Our Ref: K/22/09/

Construction of third floor extension with flat roof, first floor balcony access to sun deck, garage extension, additional driveway parking & boundary wall erected to front of property

Chelsfield 53 Coastal Road East Preston

Kingston Parish Council has the following objections and comments on the development proposed in planning application K/22/09: ☐

Drawing
Proposed Floor Plans
Proposed Roof Plan
Scale: @A1
1:50
1:100

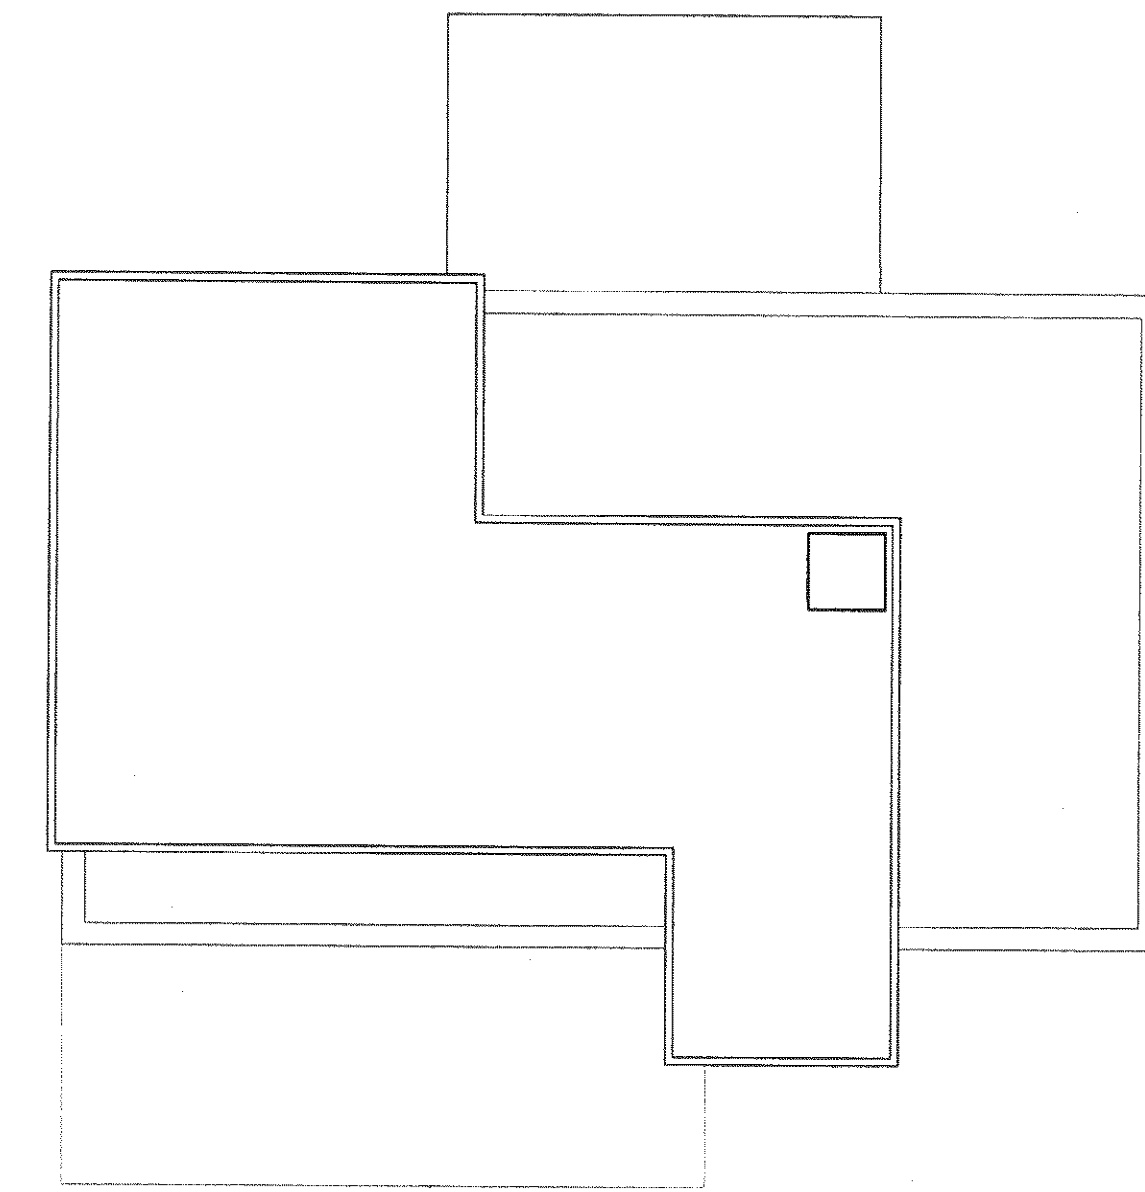
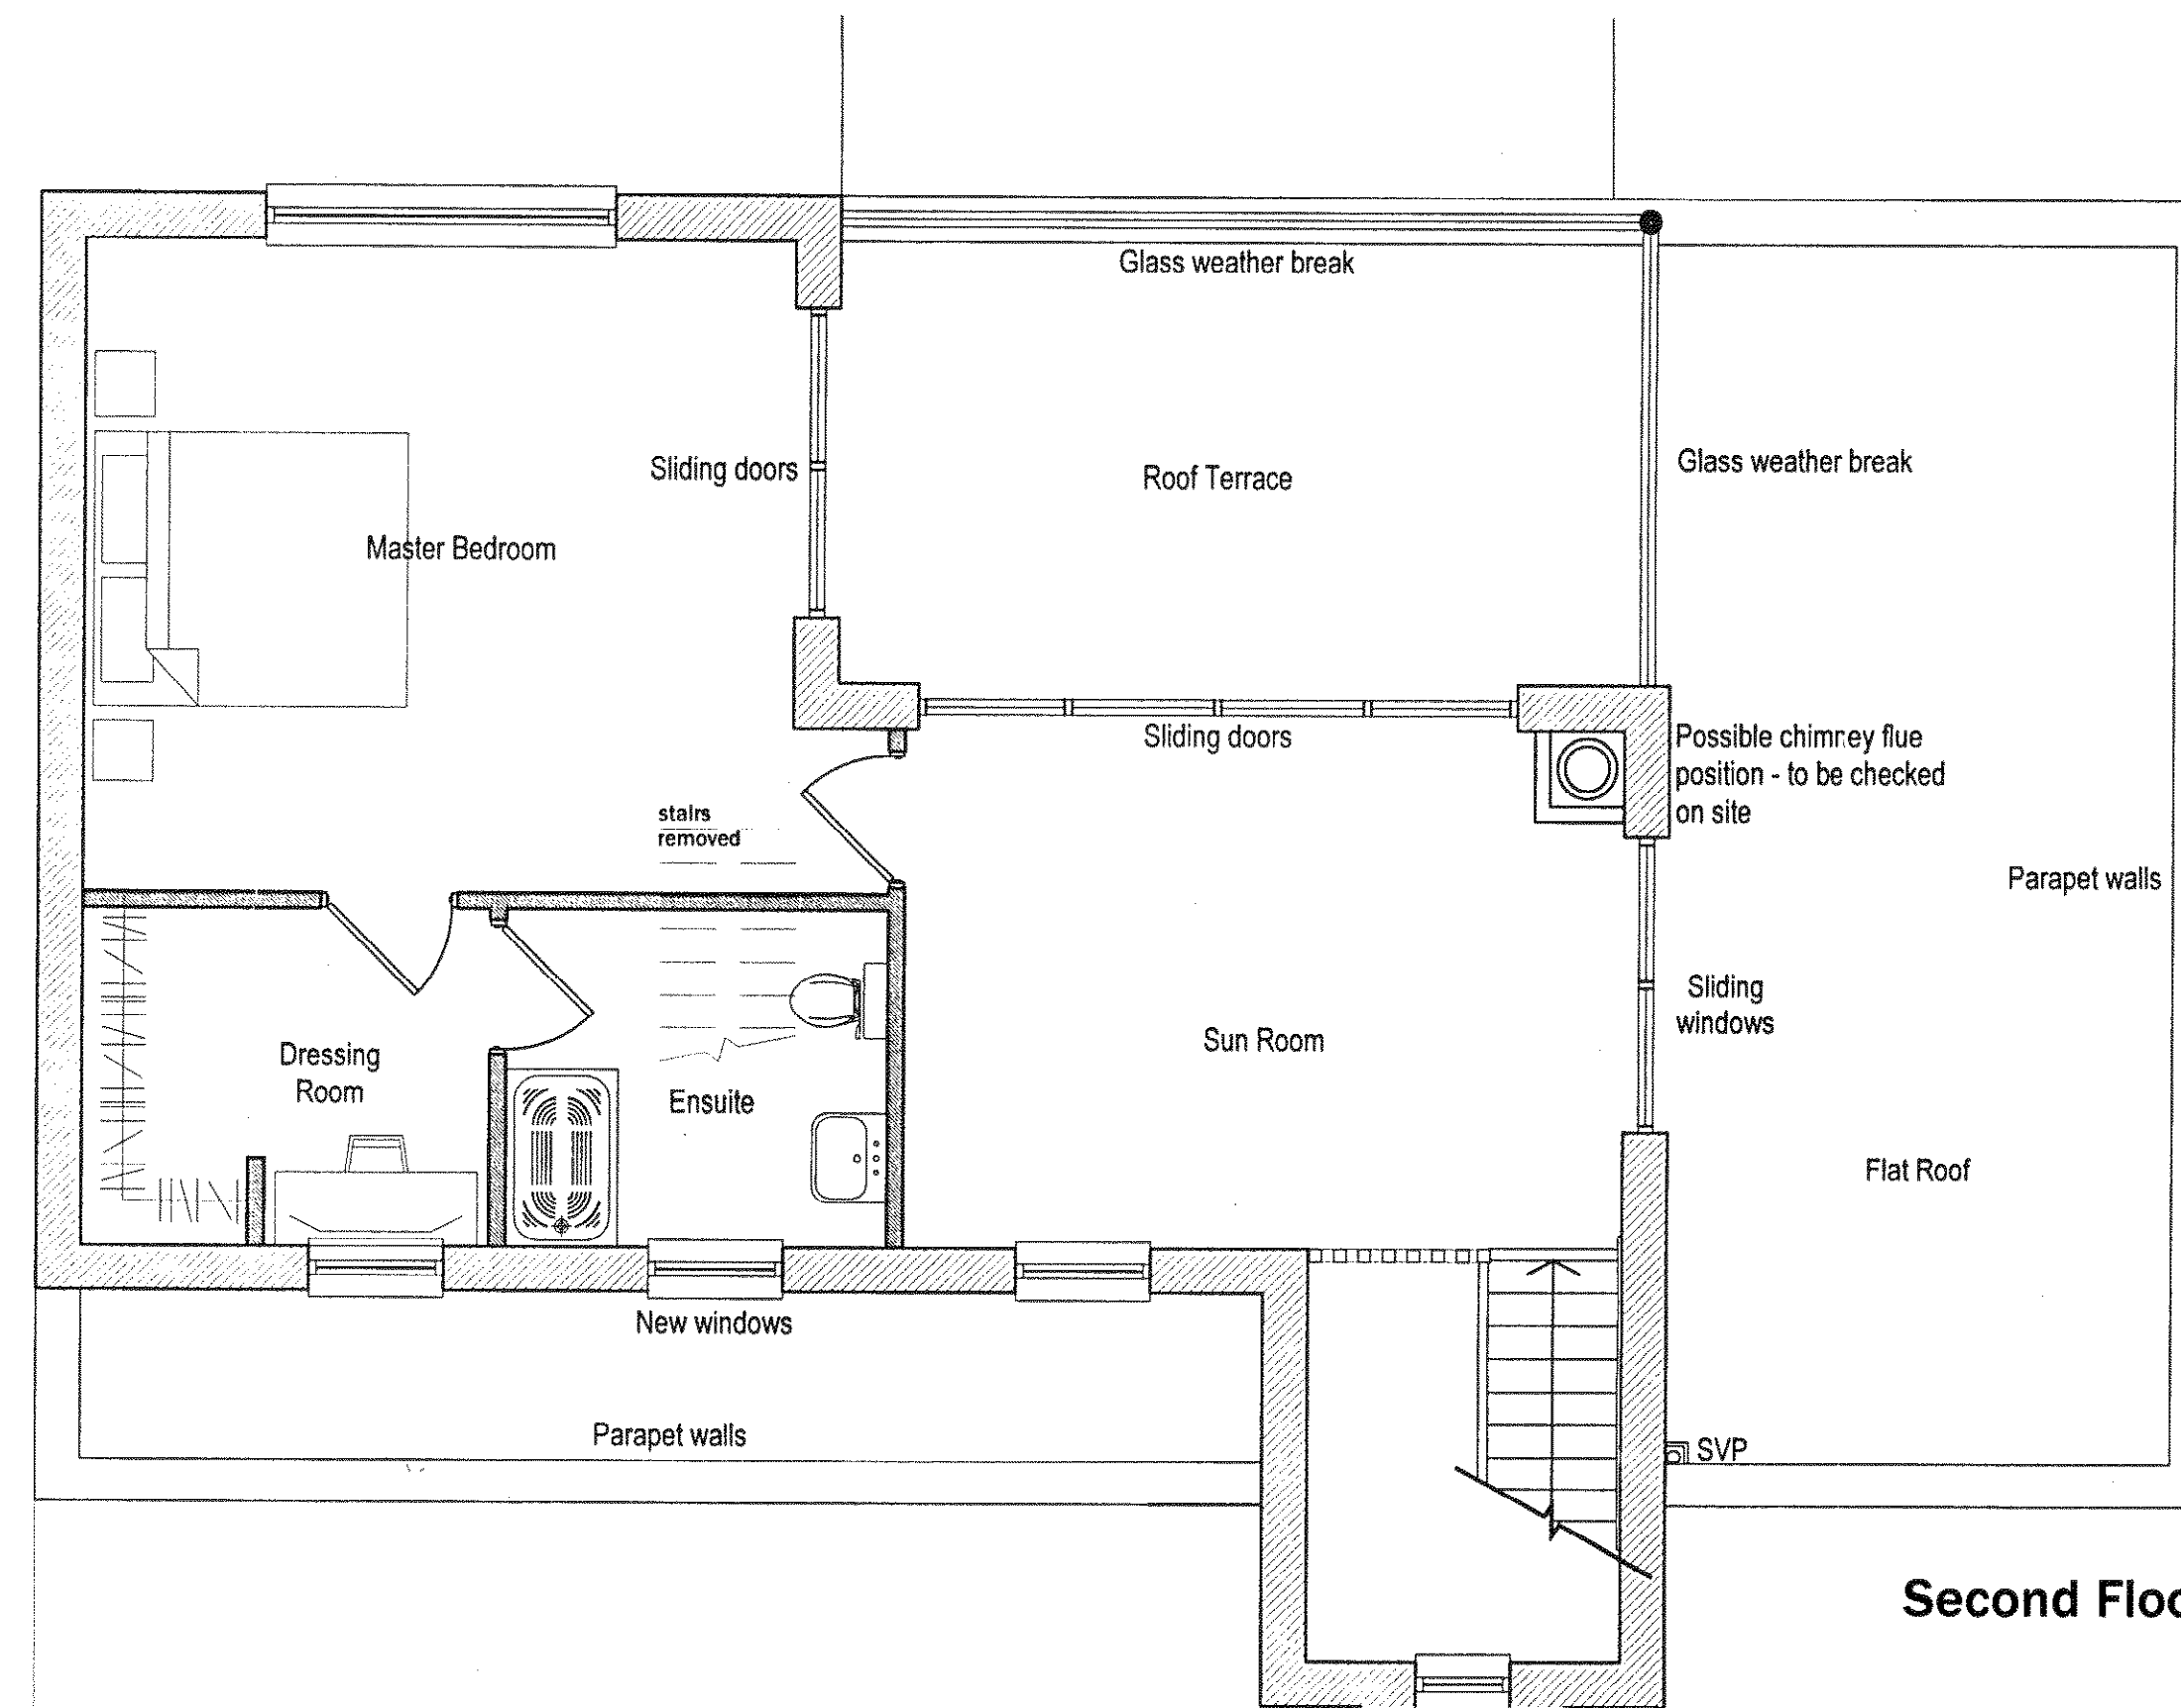
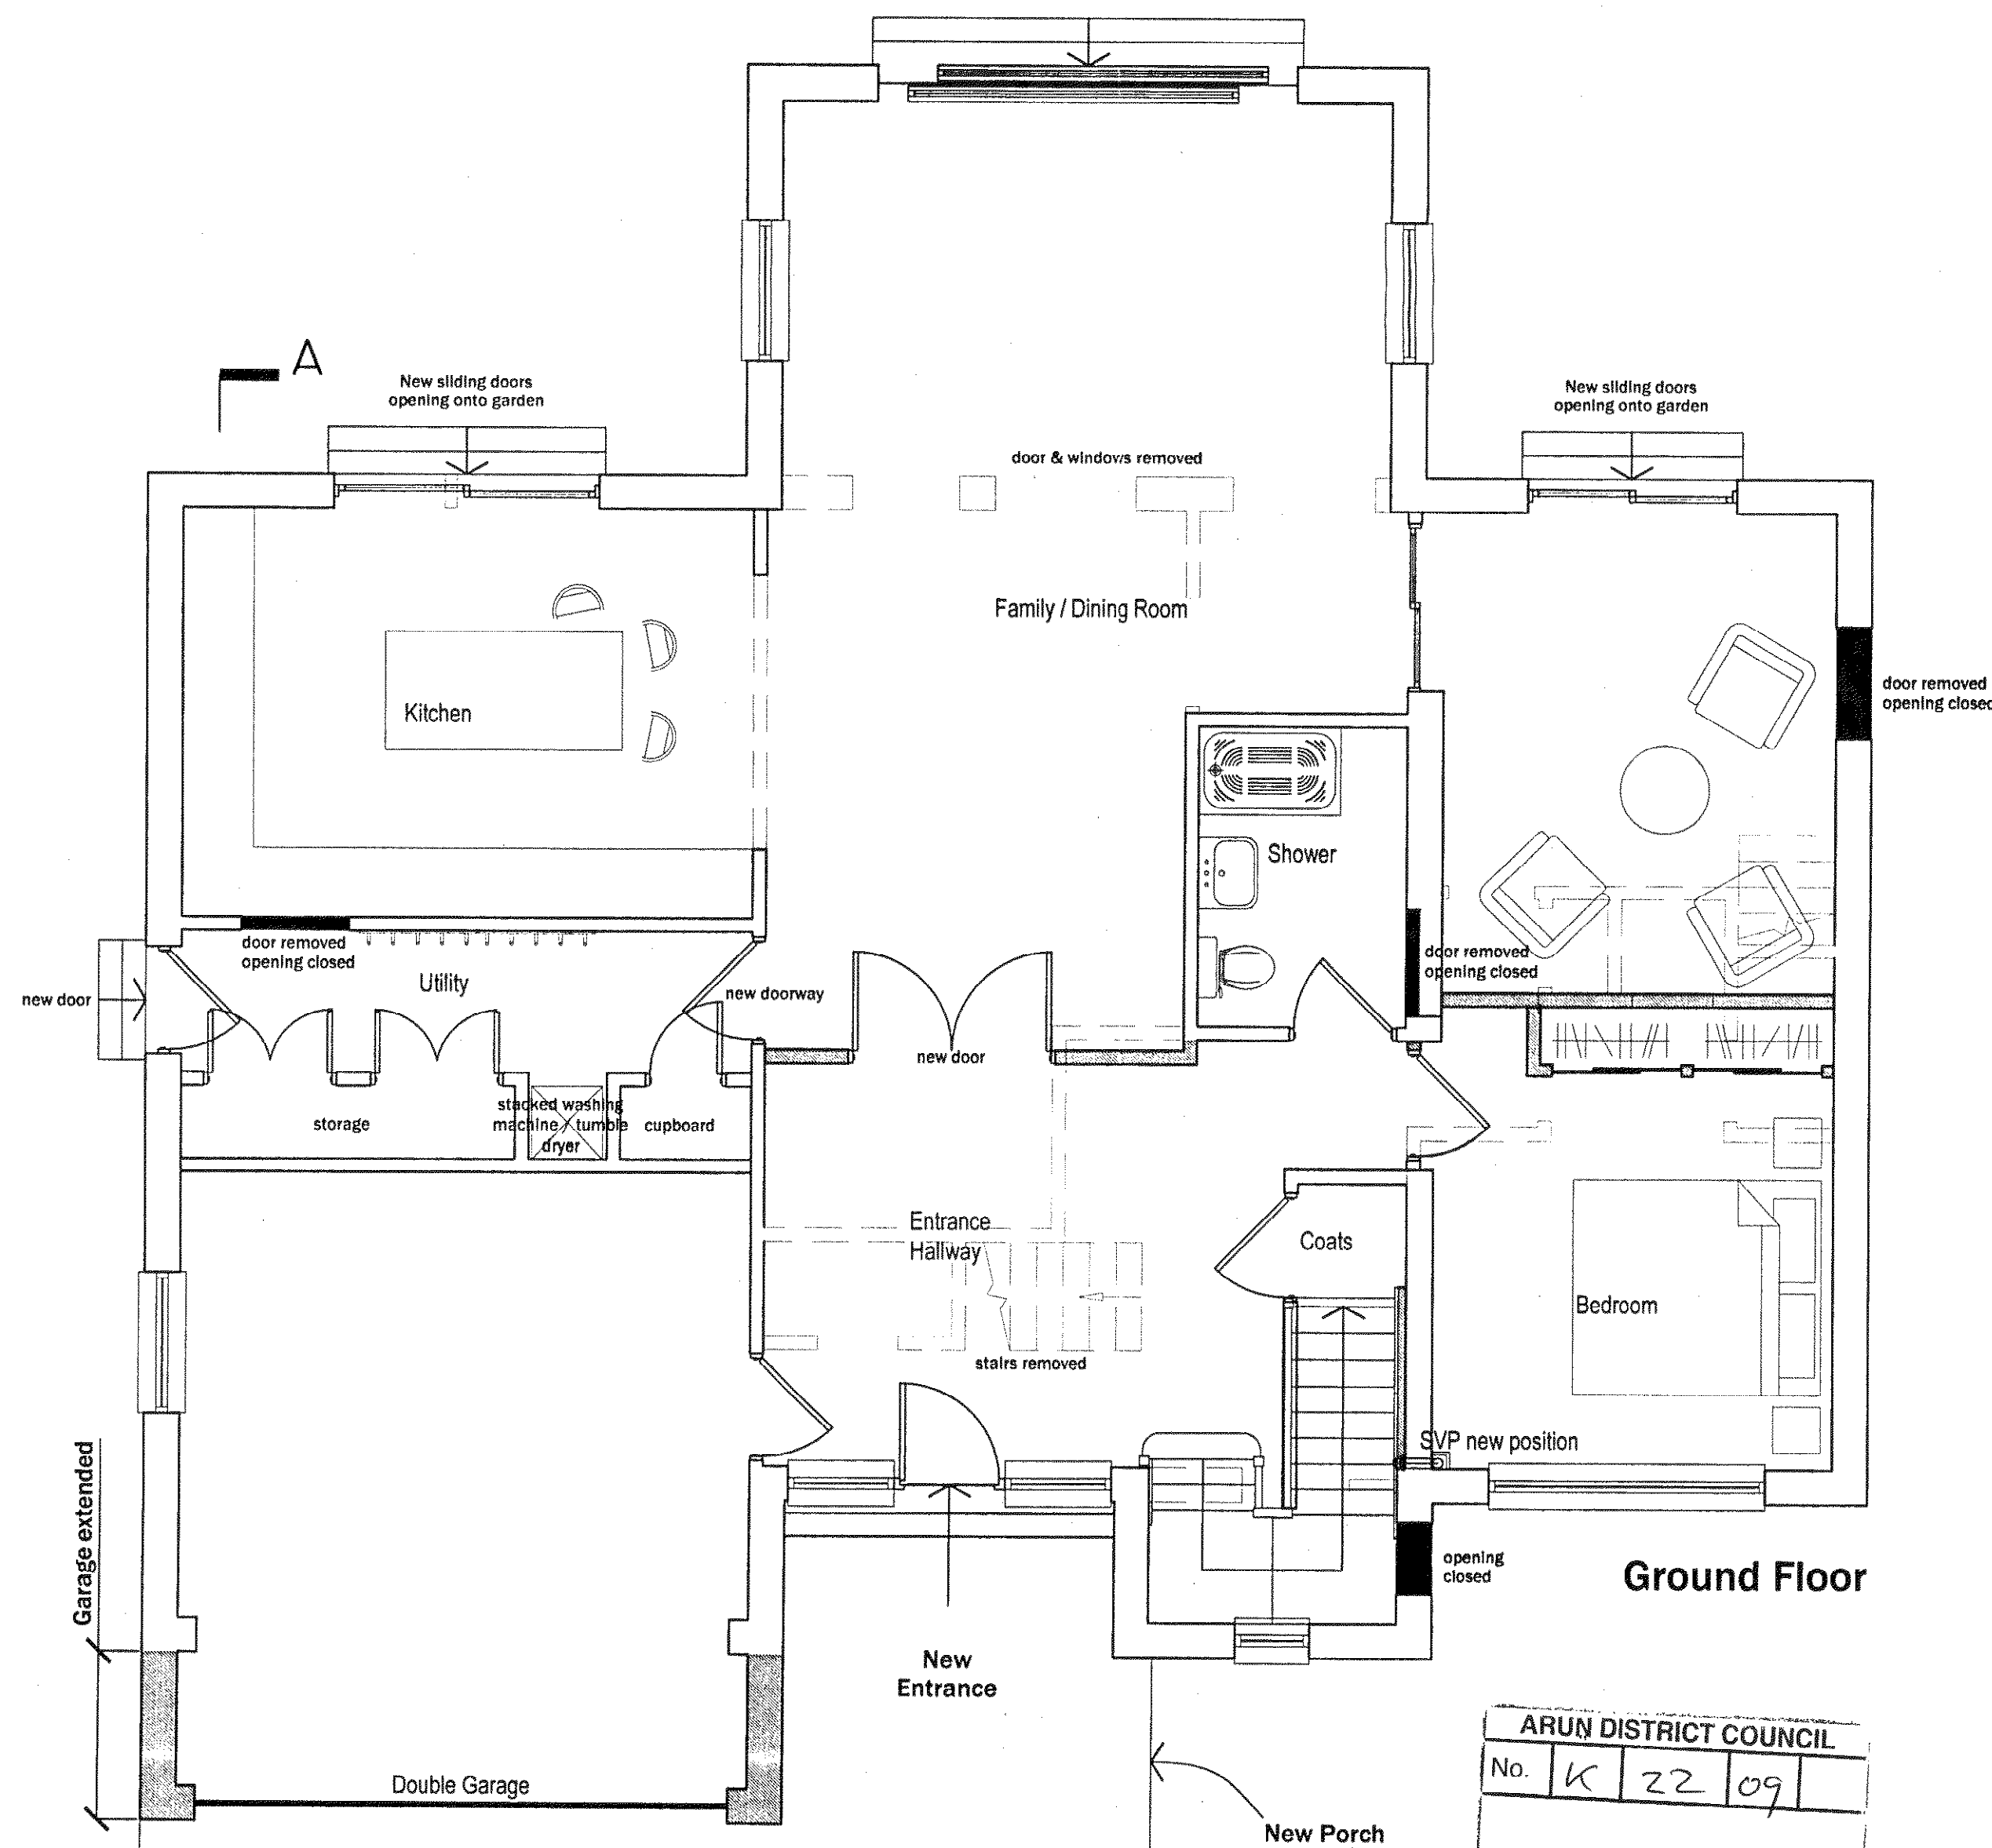
5. The proposal for a second floor balcony should be refused because it is intrusive on the privacy of neighbouring properties. ☐

6. The proposal for the extended first floor balcony should not be allowed unless opaque 1.8m high side screens are provided to the east and west of the balcony because it is intrusive on the privacy of neighbouring properties.
